**Your  
Reference** SSD-35609161

**Our  
Reference** NCA/6/2022

30 August 2022

**City of Parramatta Council submission to State Significant Development Application for a mixed-use building, including 'Build to Rent' units at 12 Hassall Street, Parramatta**

Status
DEVELOPMENT APPLICATION

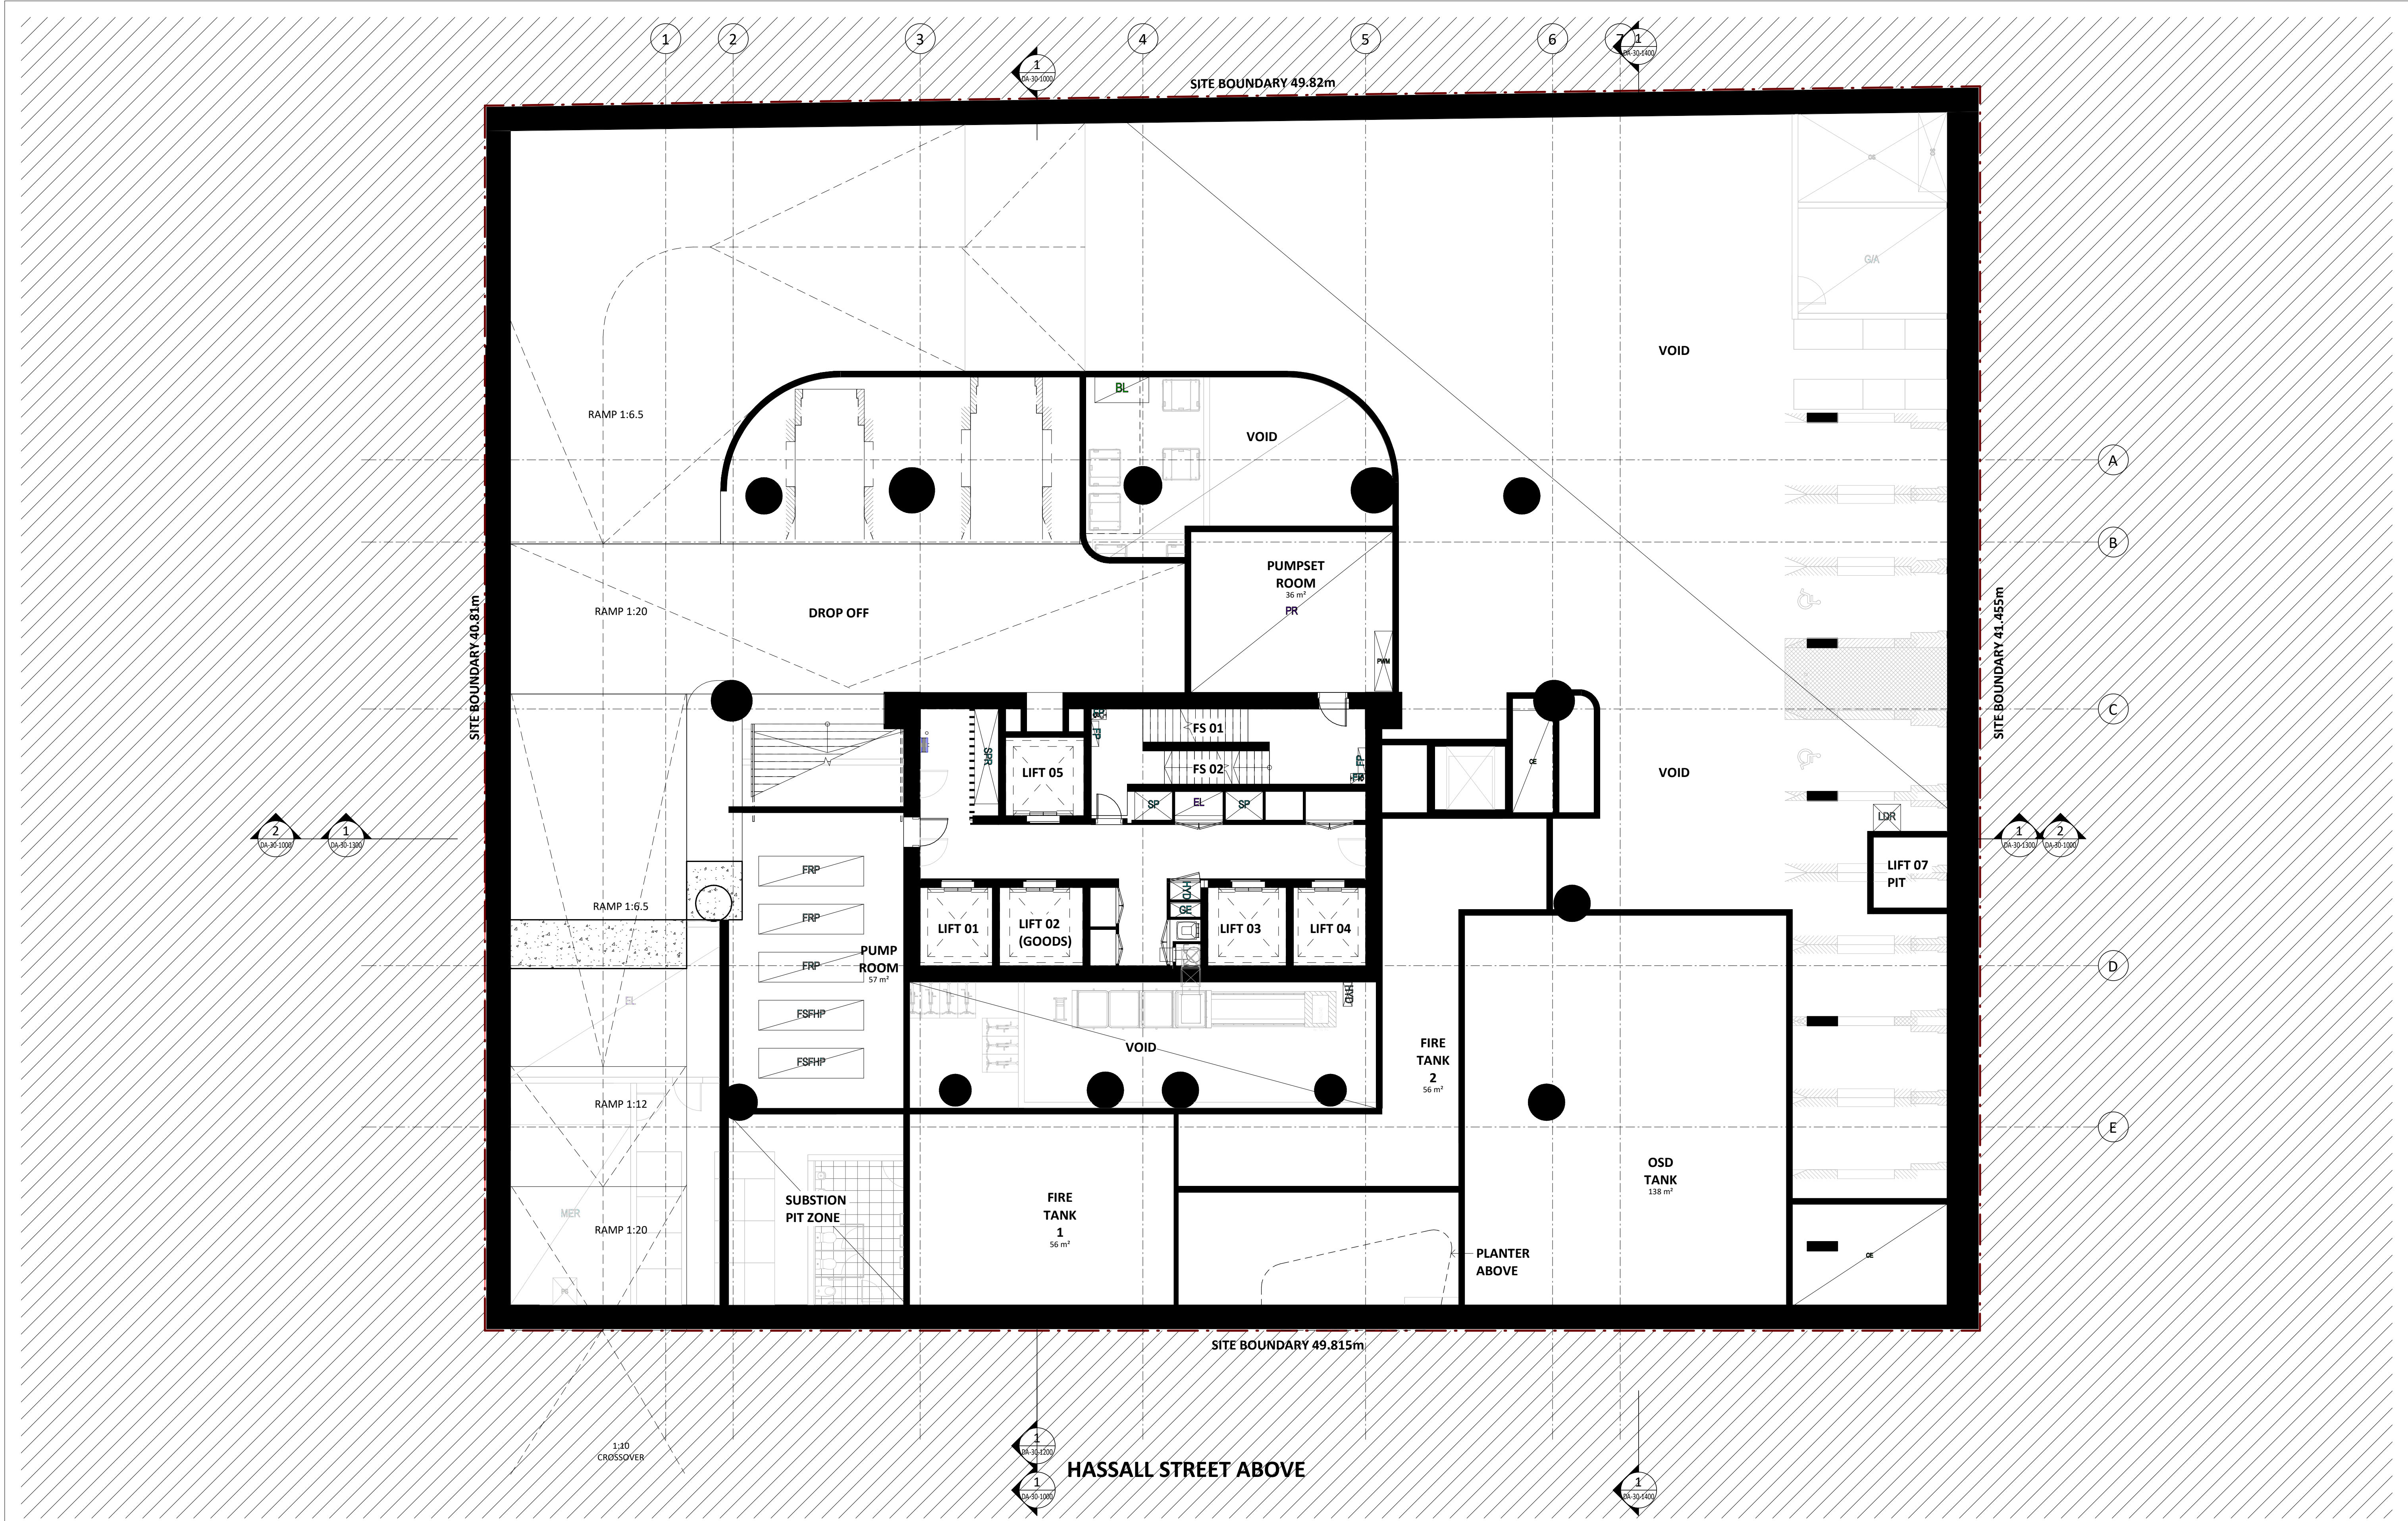
The basement plans should be amended to include the provision of lockers to support the end of trip facilities as per the requirements of Amendment 56 of the Parramatta LEP 2011.

Title
B-GENERAL ARRANGEMENT PLANS
LEVEL 00 GROUND FLOOR PLAN

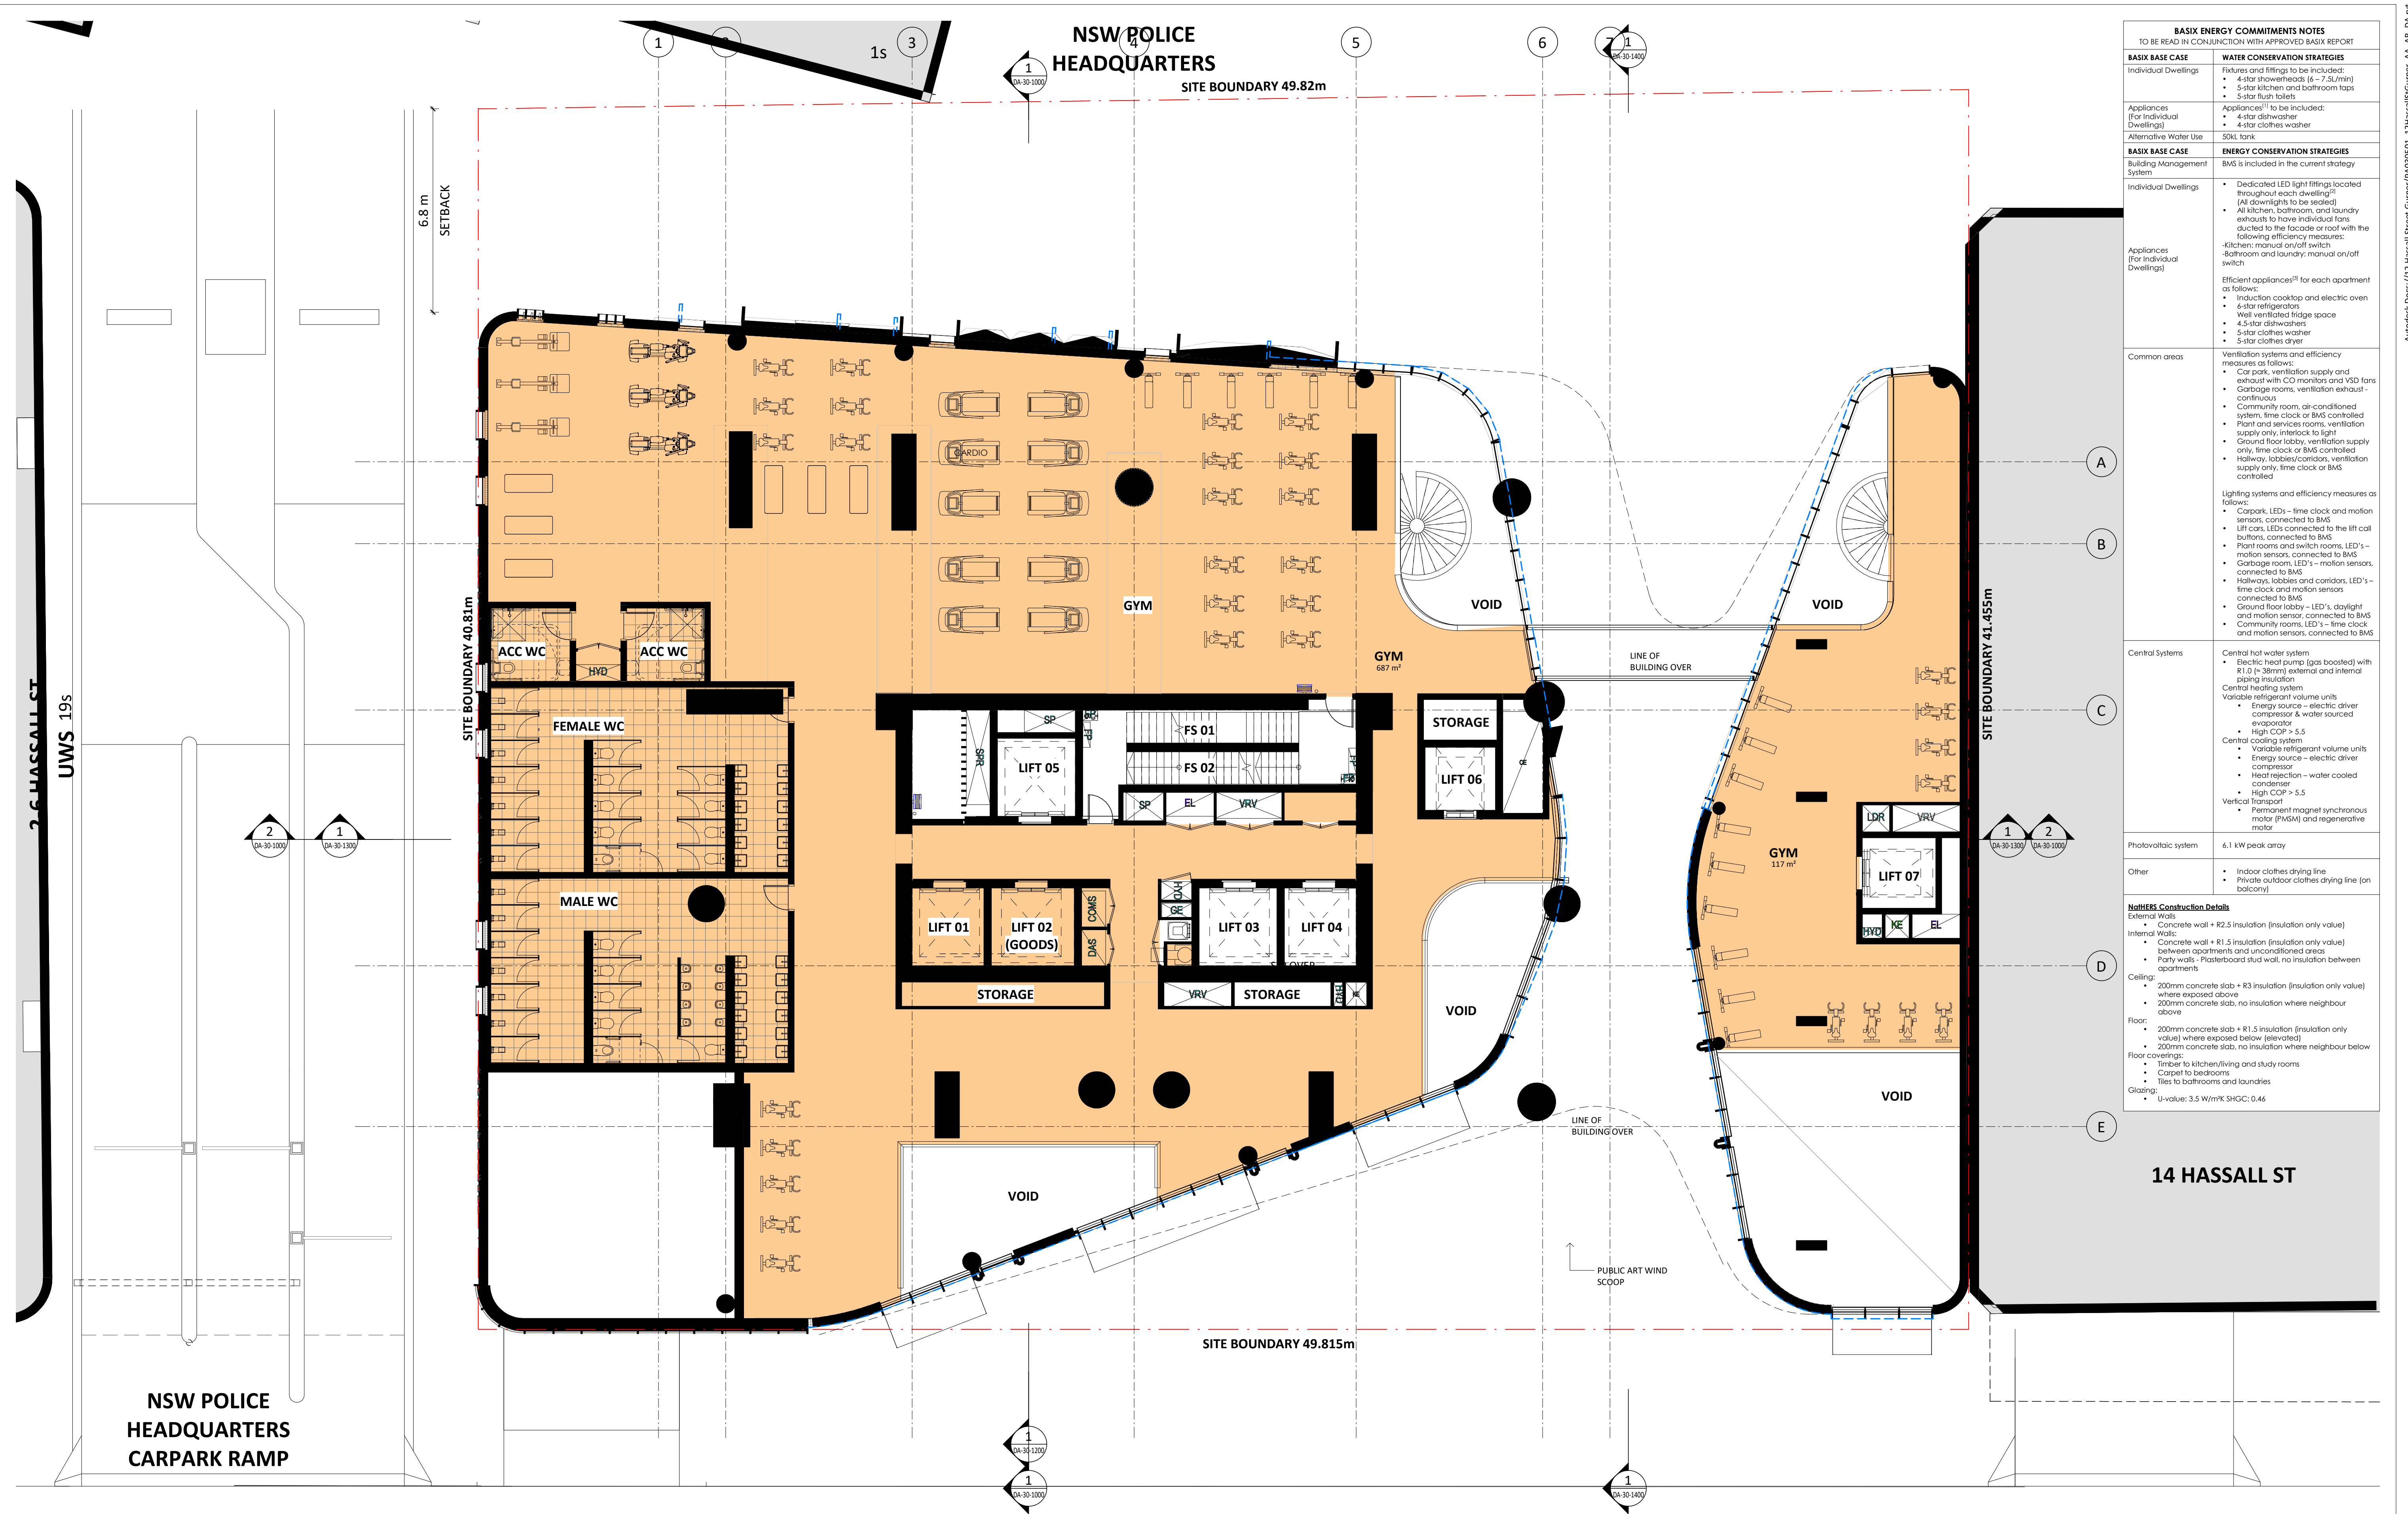
The public domain proposed as part of the ground floor plan, dwg DA-10-1000 rev A, D08630588 Architectural Drawings 1 - GQ Parramatta (SSD-35609161) is satisfactory to Council Officers with recommended conditions of consent found at **Attachment 1**.

The building line has been withdrawn into the site creating a significant dent into the street wall thus affecting the shoreline required by a person with vision issues. Therefore, a clearly defined accessible path of travel should be provided from the property building to the principal entries of the development as per AS1428.2 and BCA D3. **Attachment 1** provides for universal access matters to be included as part of recommended conditions of consent.

- The approved ground floor plan DA-10-1000 rev A drawing submitted as part of D08630588 Architectural Drawings 1- GQ Parramatta (SSD-35609161) - NCA 6 2022
- All the conditions listed in this consent.
